Community Services Planning Department

RESPONSE TO COMMENTS MAY 26, 2020

Reference: Aspen Ranch Preliminary Plat

CITY FILE NO.:

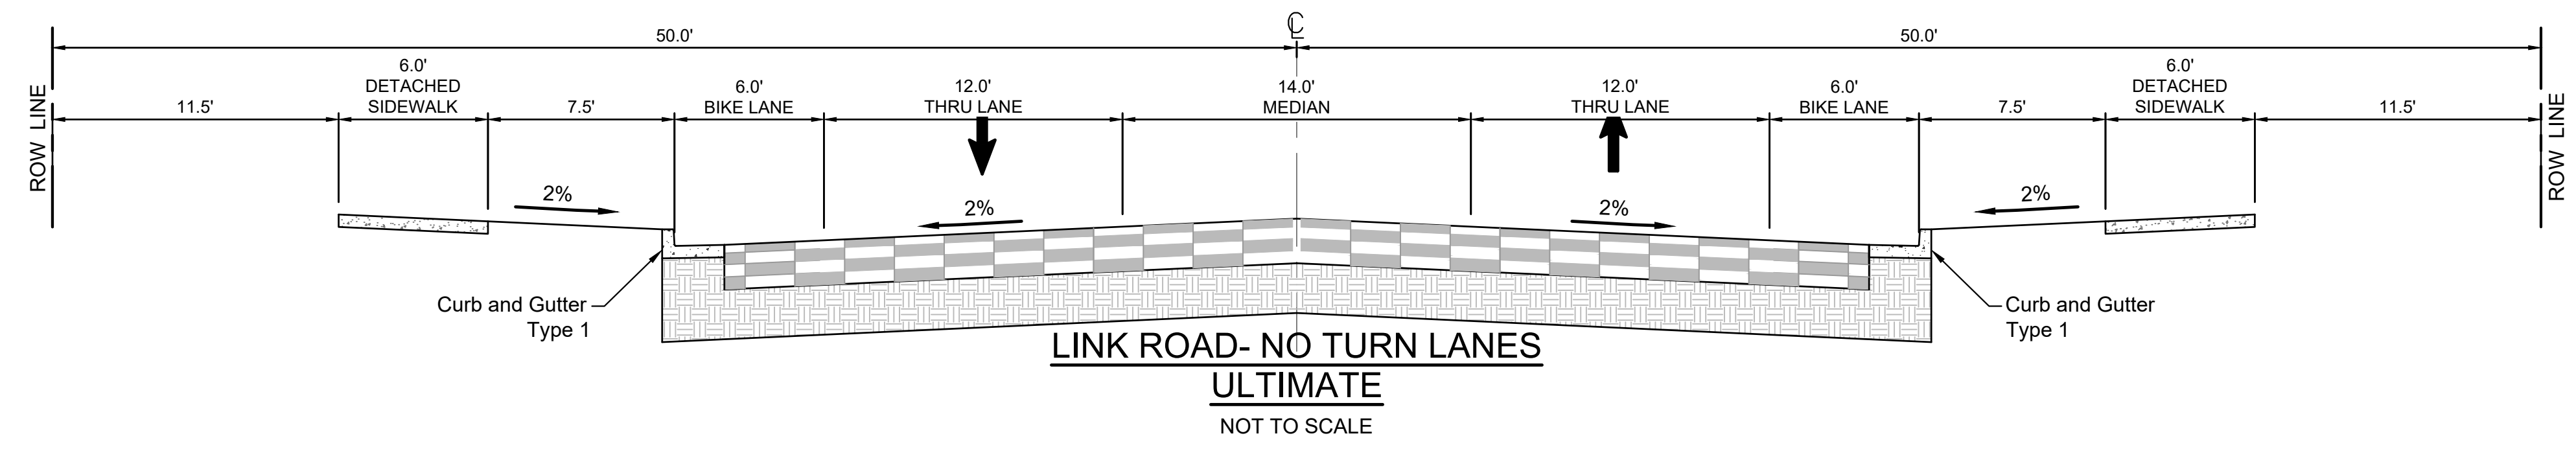
The 15' front-lot Utility Easements shown on the Residential Local Roadway Cross-section on Sheet 4 are not reflected anywhere else on the plat documents. **ADDRESSED: THE ROADWAY CROSS SECTIONS AS WELL AS GENERAL NOTE #14 ON THE COVER SHEET ILLUSTRATE THE 15' FRONT LOT EASEMENT.**

SP02
SHEET 6 OF 22

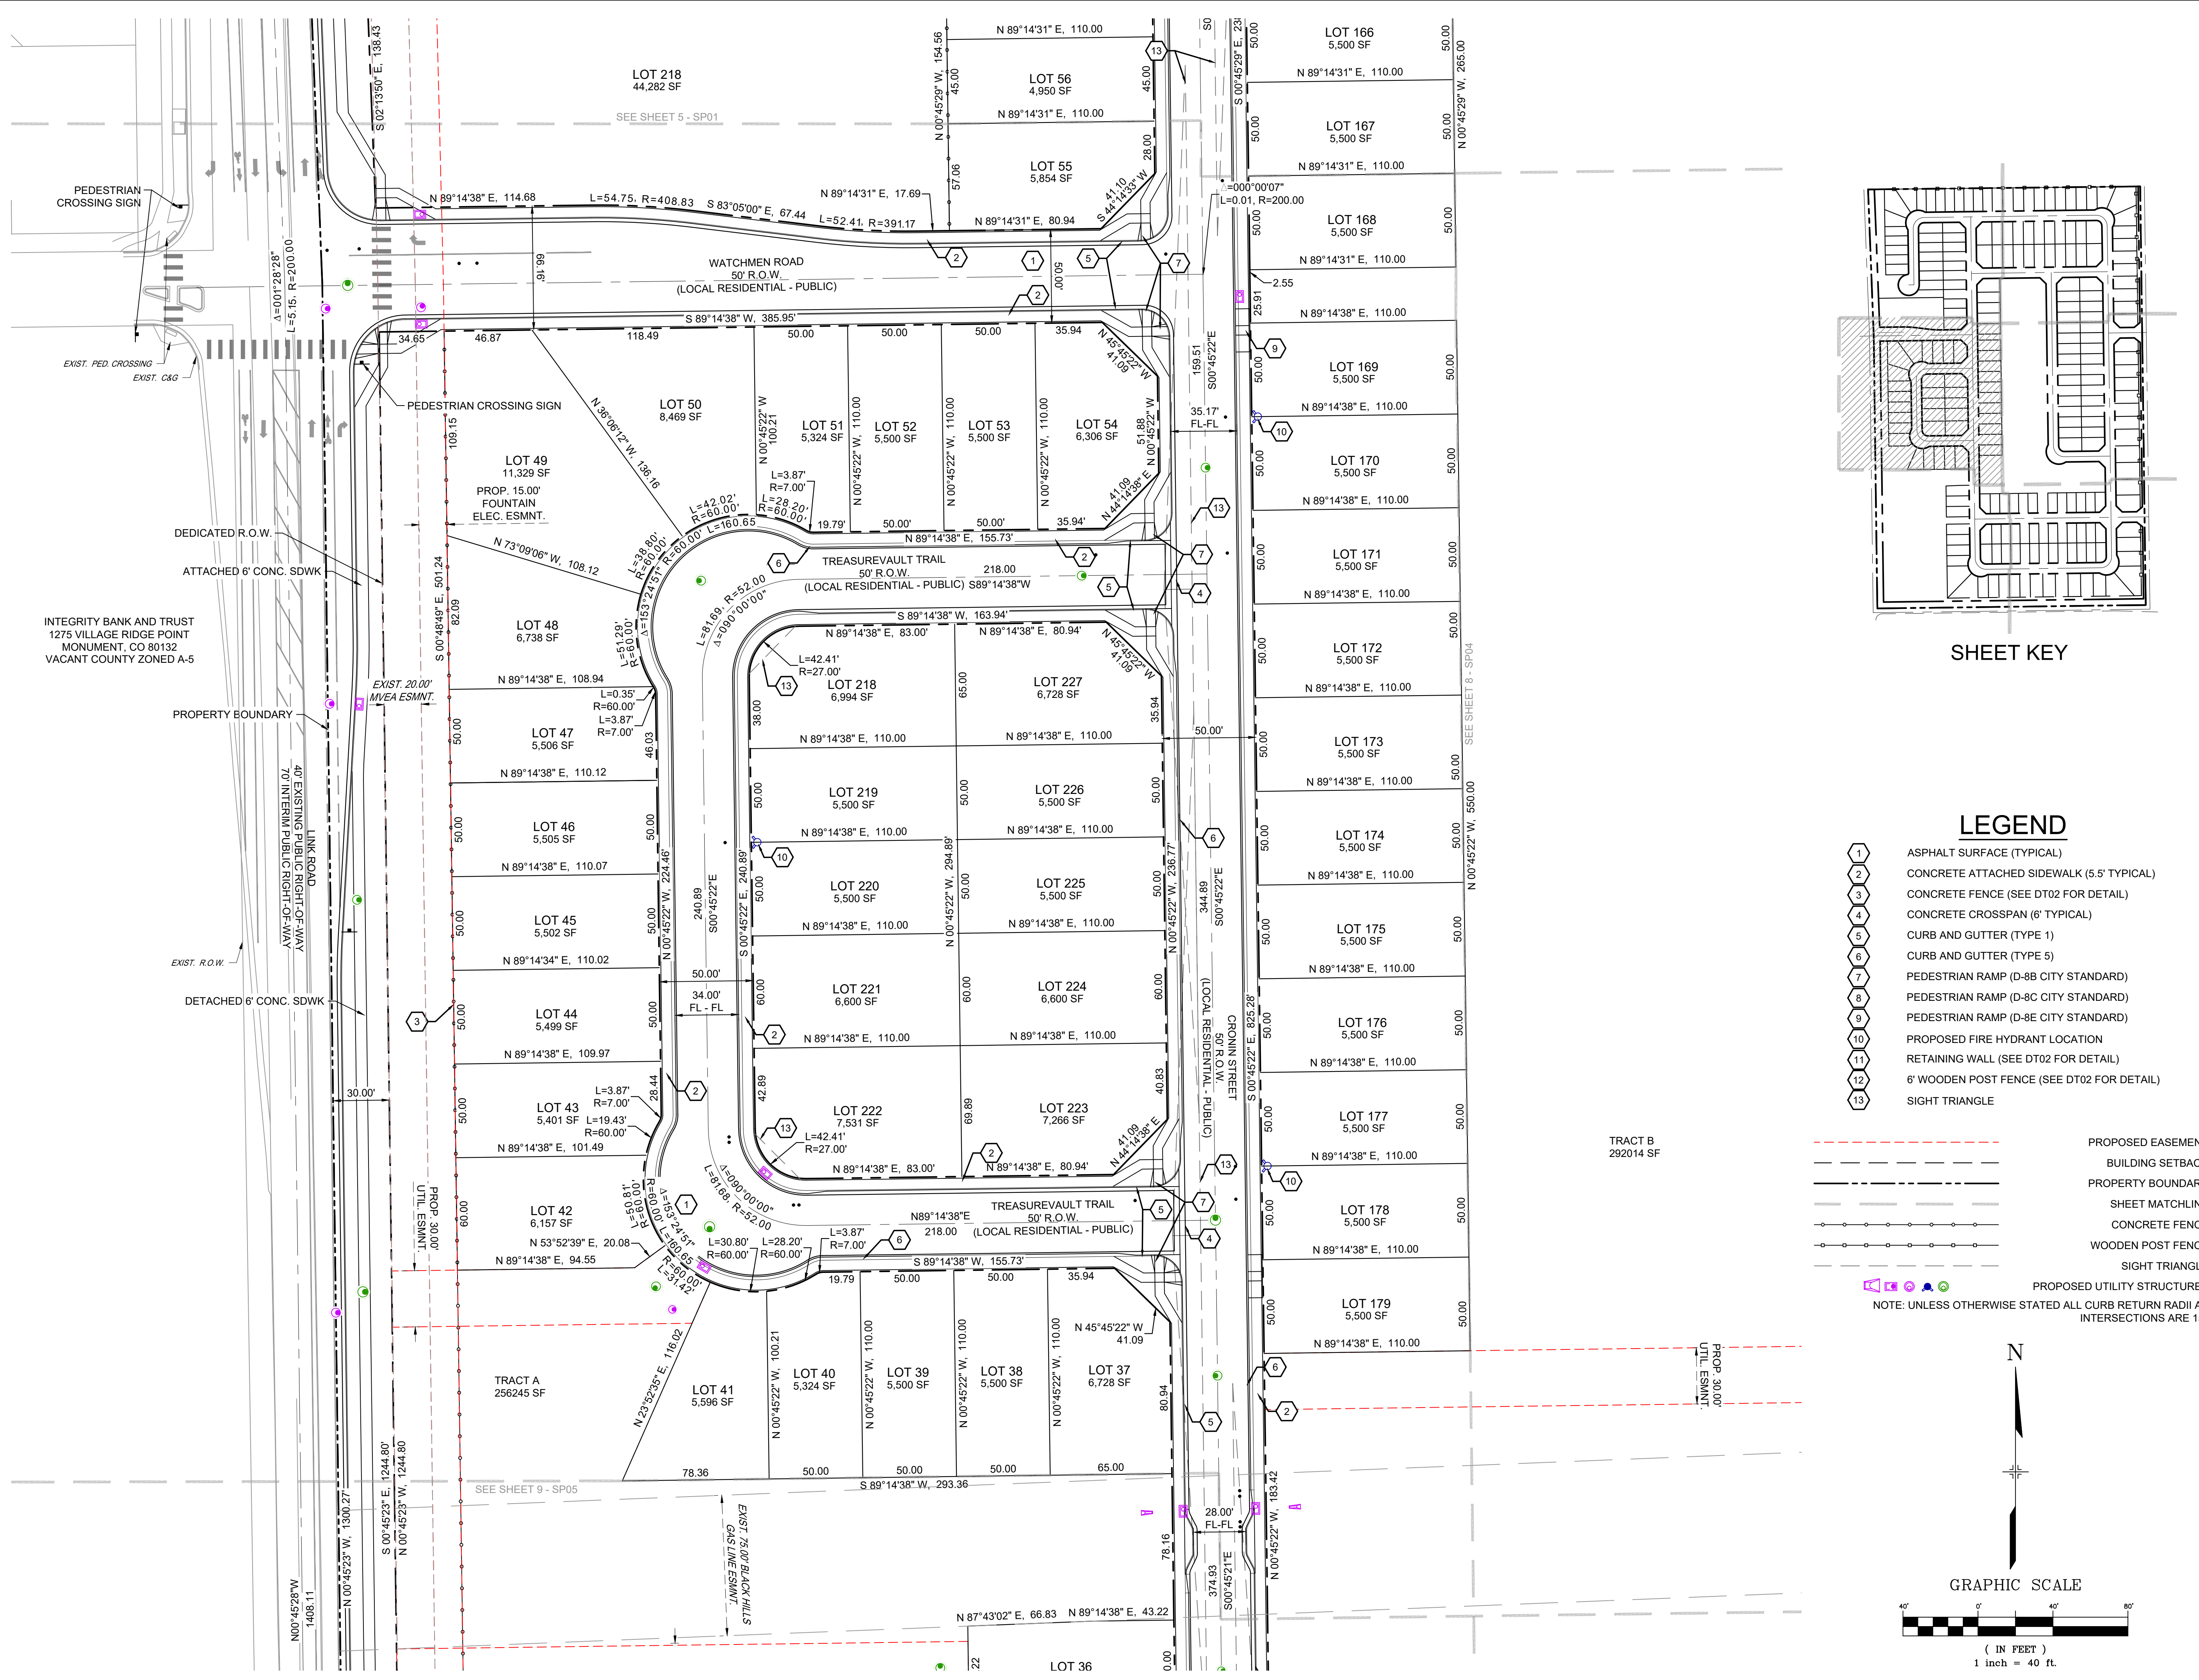
1. What is the E/W easement that is shown crossing Tract B and various lots? It appears to be in the same location as a former right of way that has been vacated. Is this a separate easement? **ADDRESSED: PER DOCUMENTATION PROVIDED BY CITY STAFF, THIS ROW HAS BEEN VACATED AND THUS REMOVED FROM ALL DRAWINGS.**

SHEET 7 OF 22

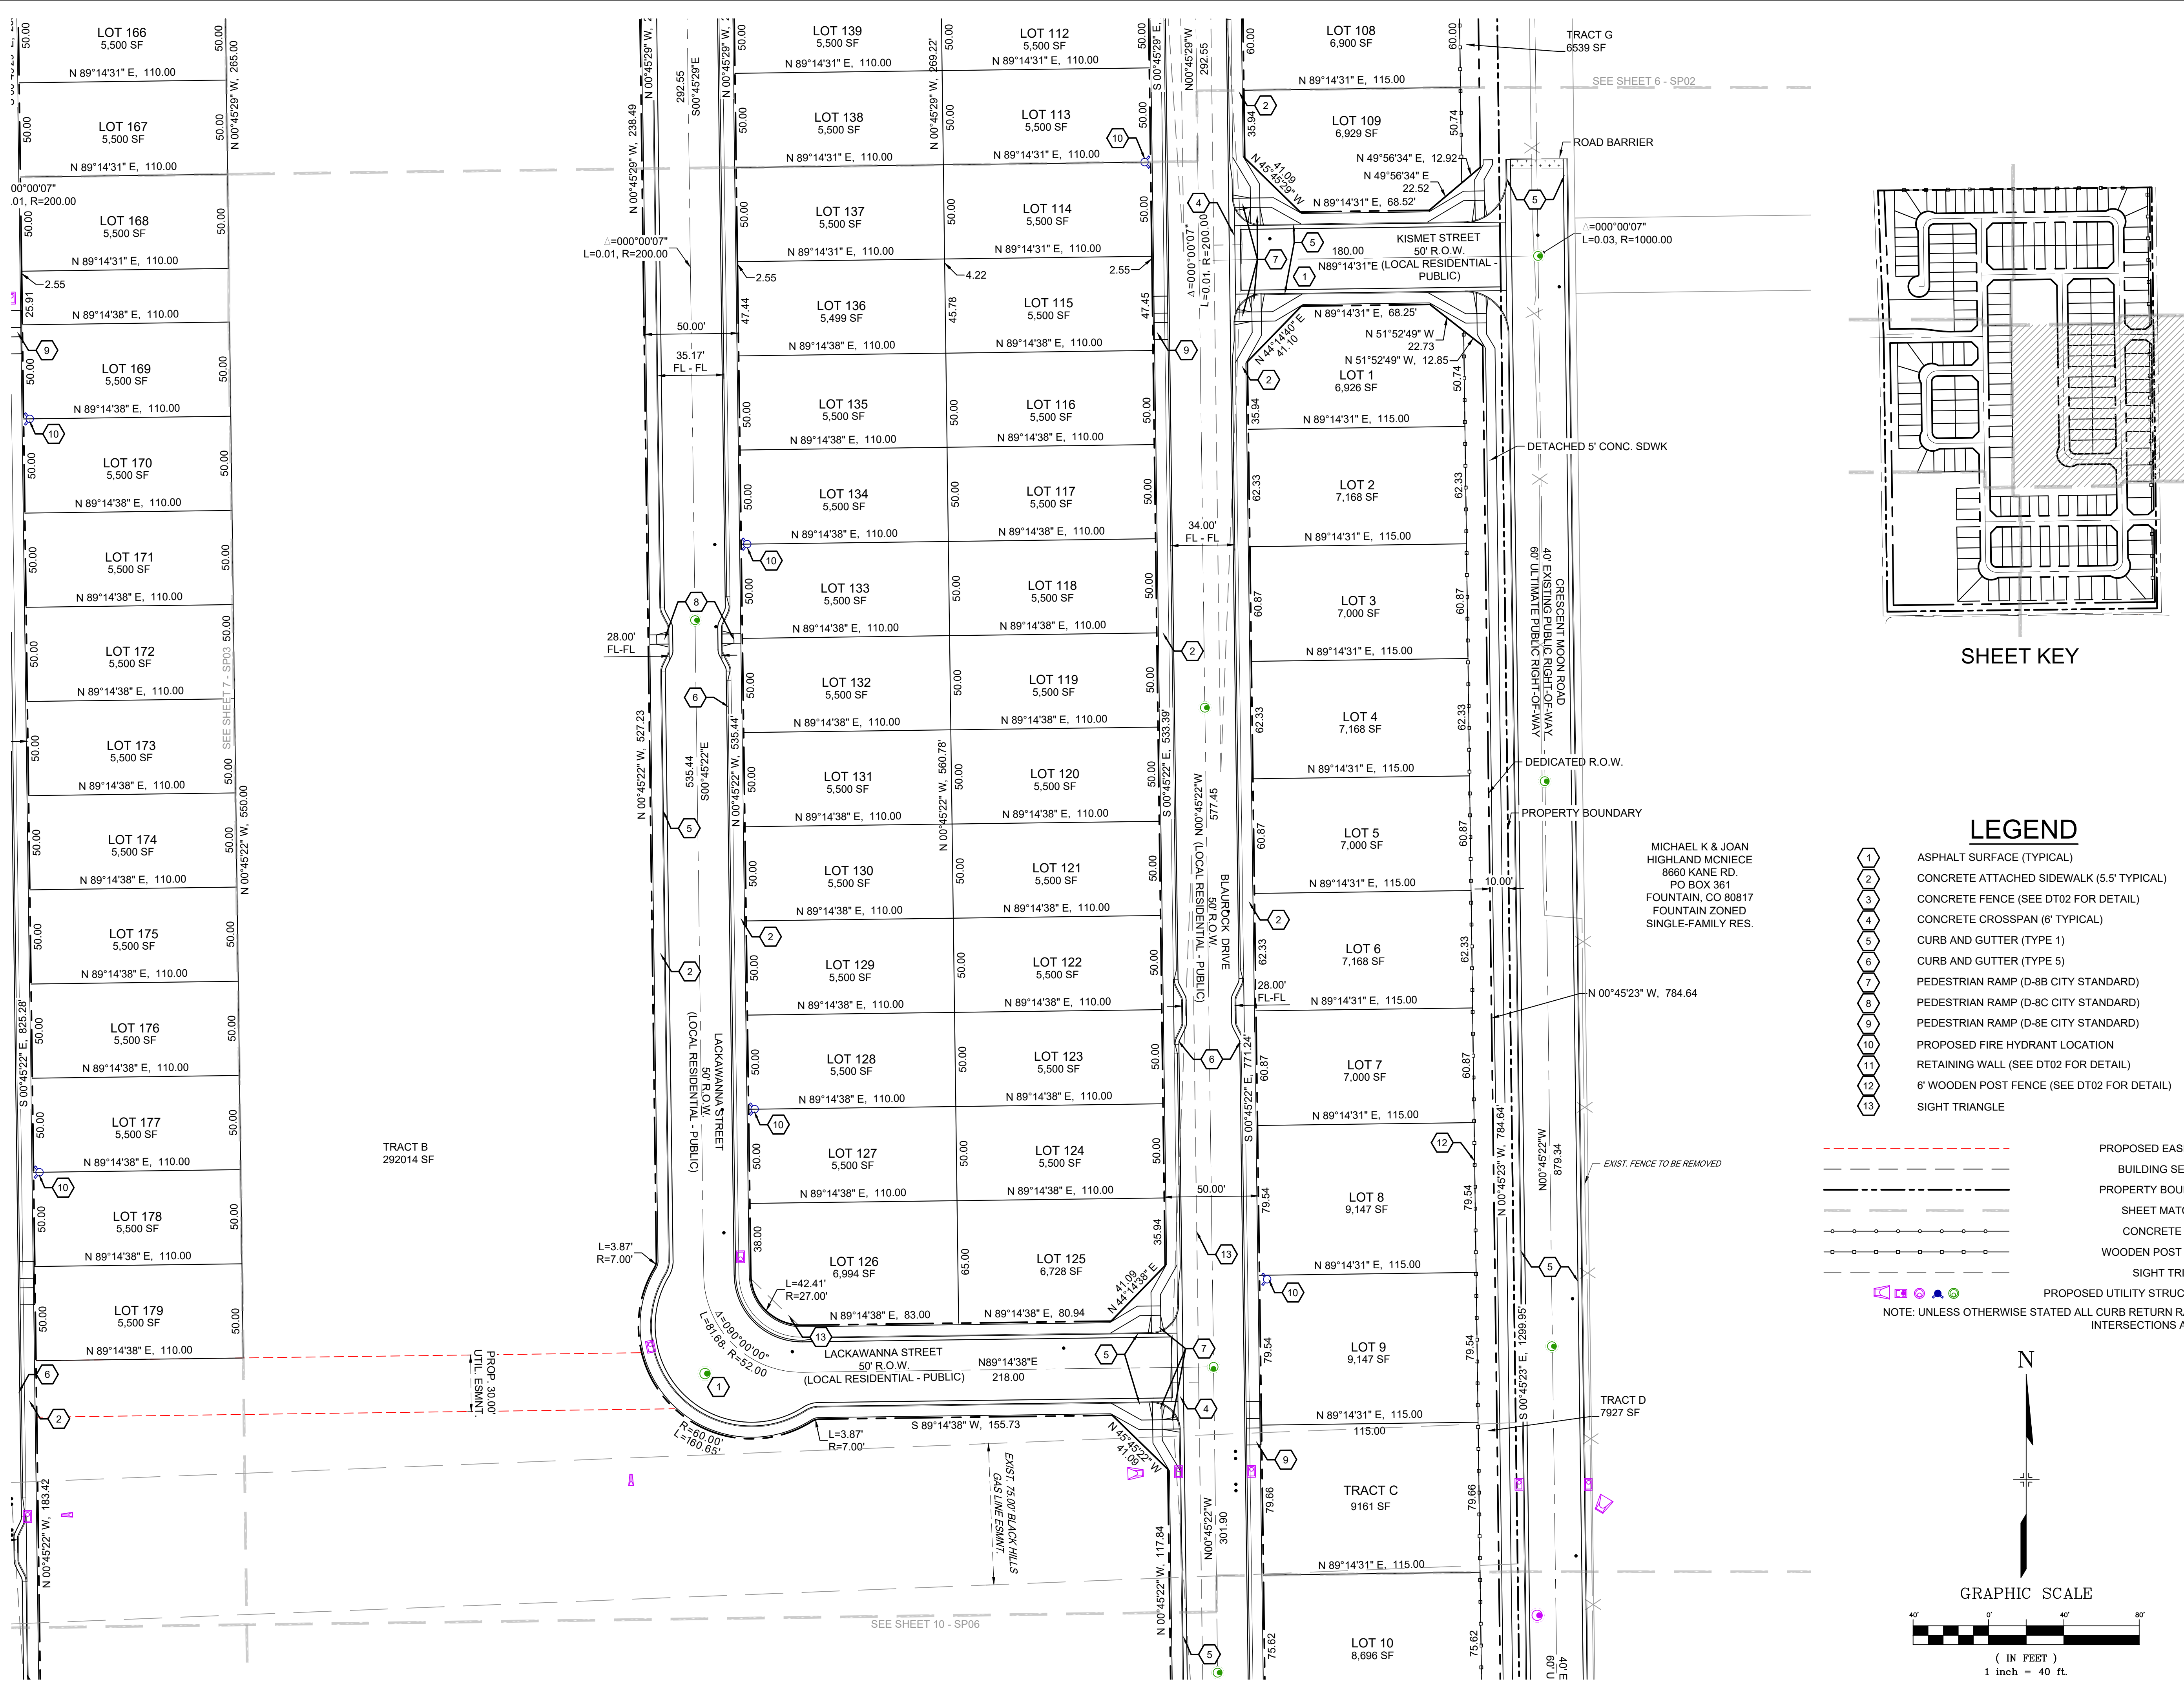
1. Same comment as sheet 6. Confirm what this easement is for **ADDRESSED: PER DOCUMENTATION PROVIDED BY CITY STAFF, THIS ROW HAS BEEN VACATED AND THUS REMOVED FROM ALL DRAWINGS.**
